Subject: ADC Planning Application EP/67/20/PL for 47 The Ridings, East Preston, BN16 2TW

DRAWING TITLE
PROPOSED SITE LAYOUT

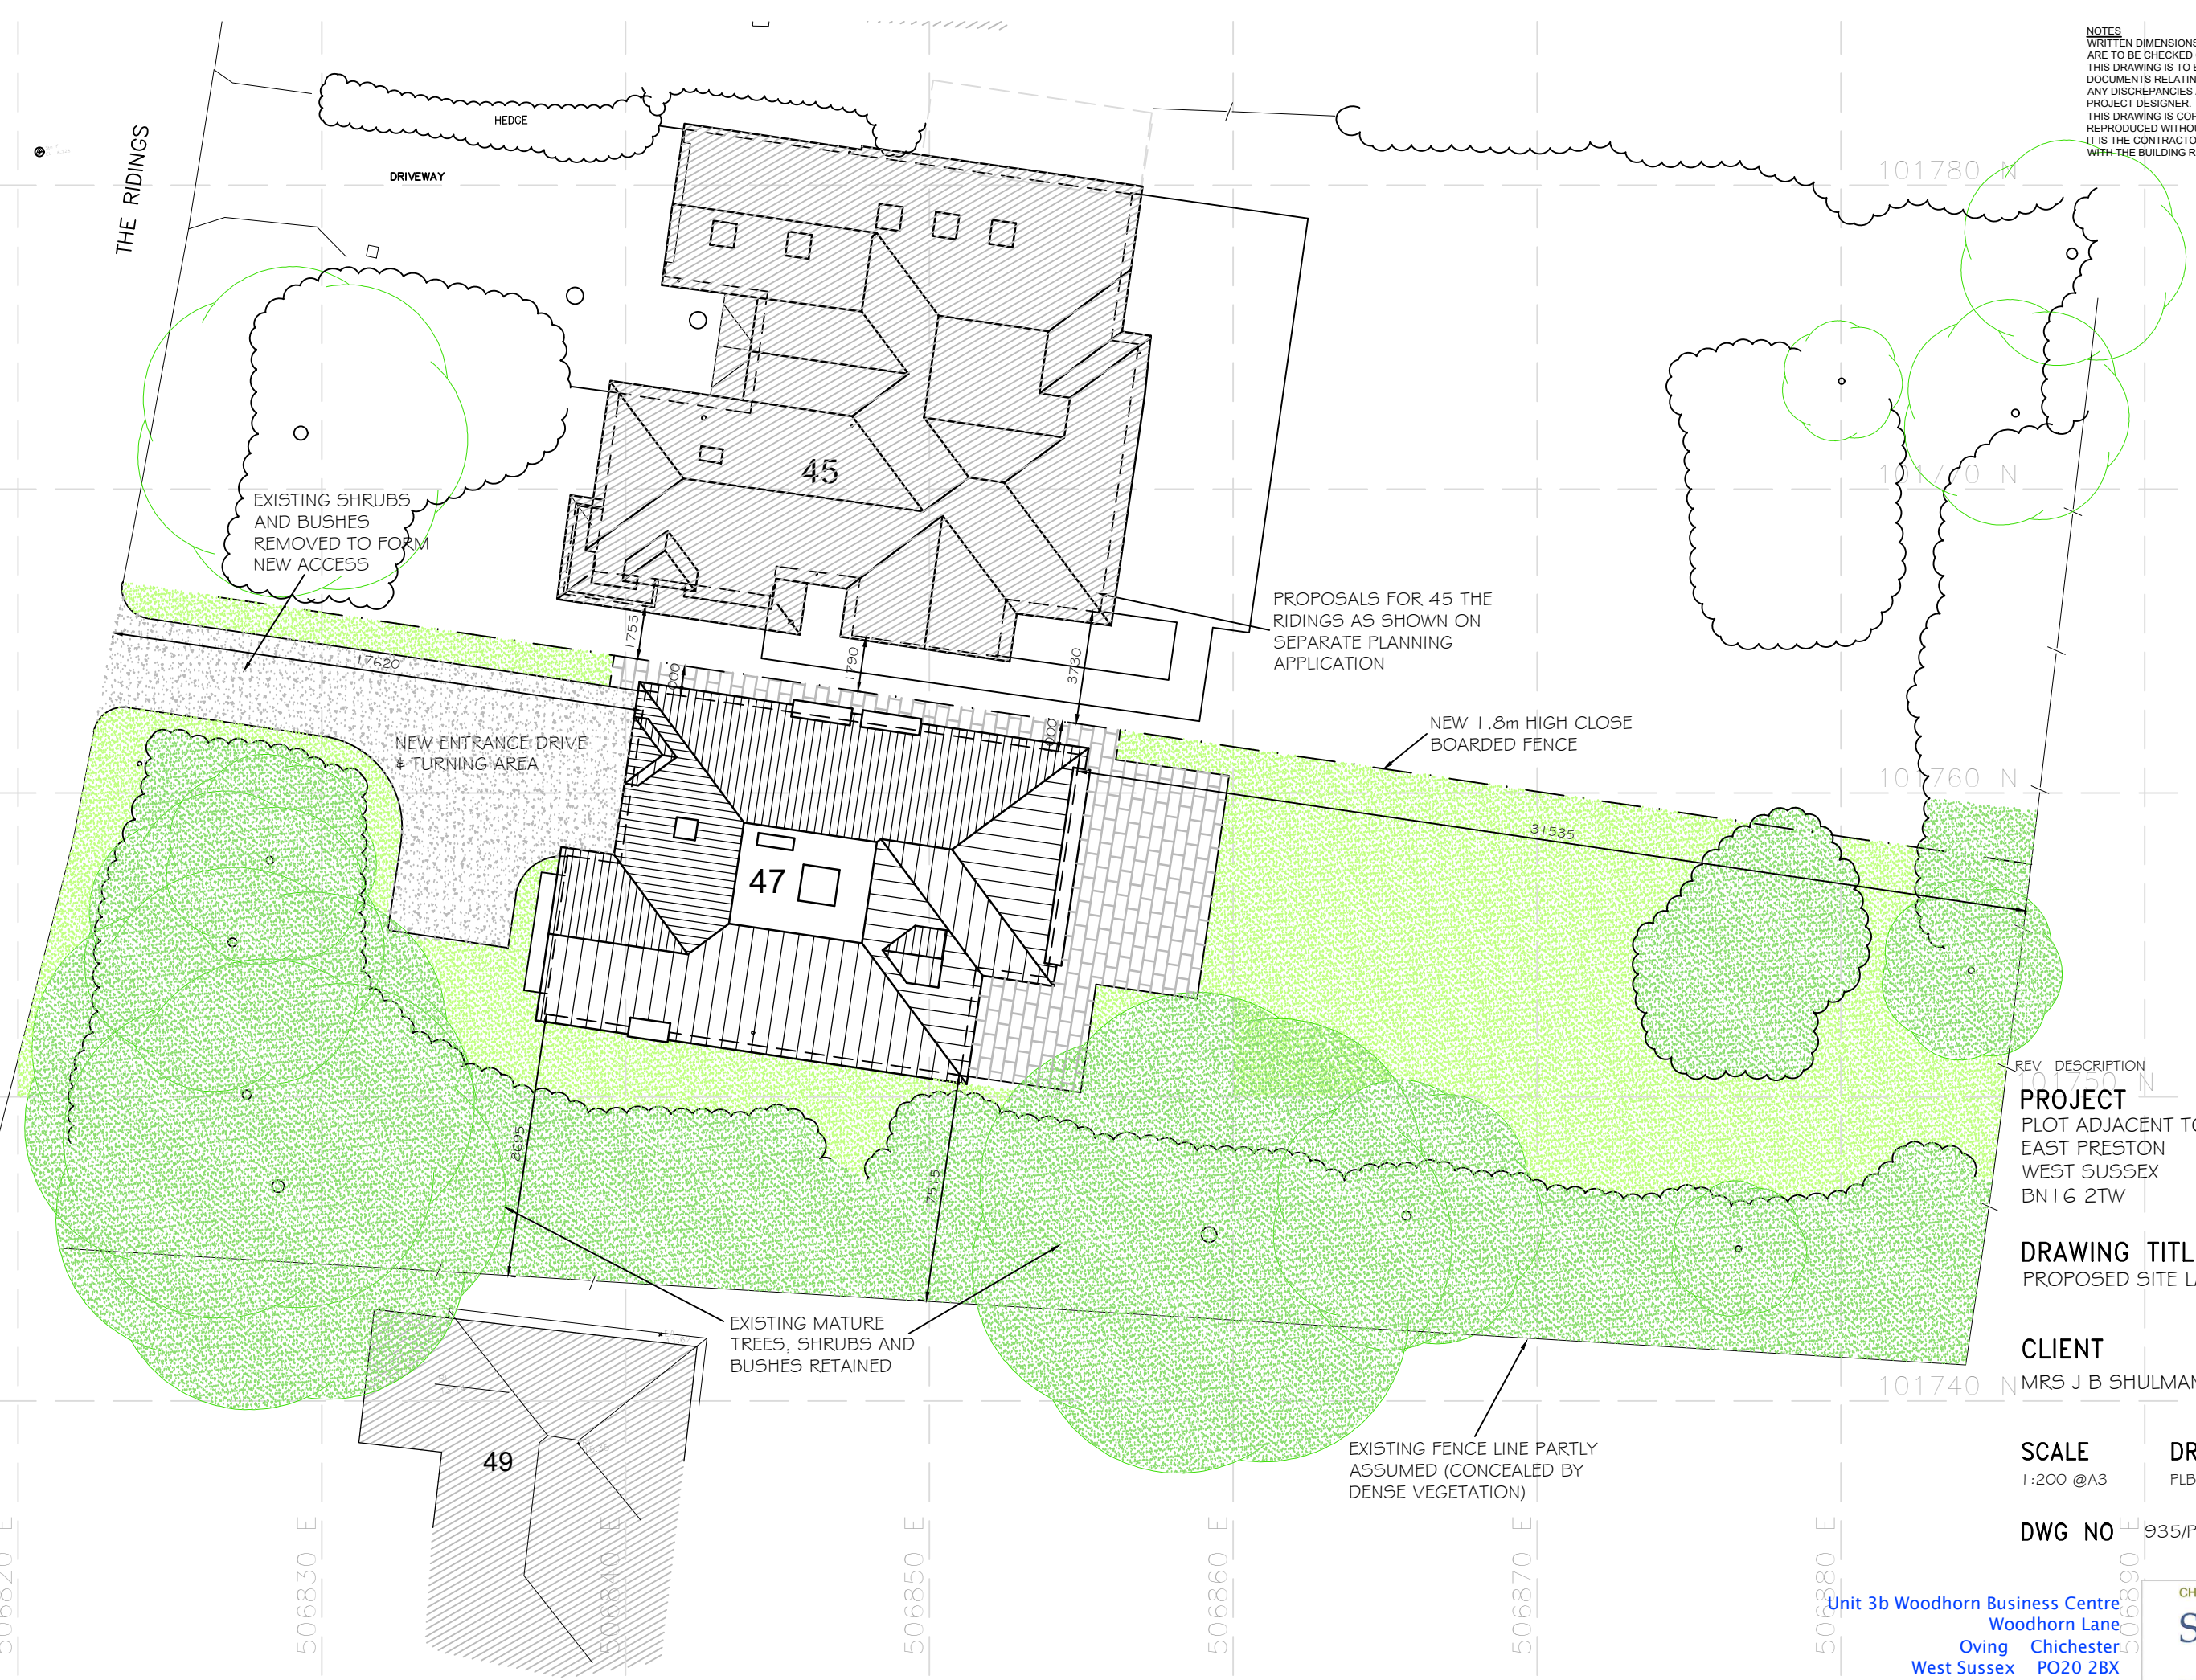
We note that this proposal is for a large (6-bedroom with 5 bathrooms/en suites) house, yet it is apparently to have only a single garage and, from the plans submitted, really quite a small parking and turning area in front of it. We do wonder where the number of vehicles normally associated with a 6-bedroomed house and their visitors are supposed to park when the house is completed? The Willowhayne Estate has a stated policy that vehicles may not be parked on Estate roads.
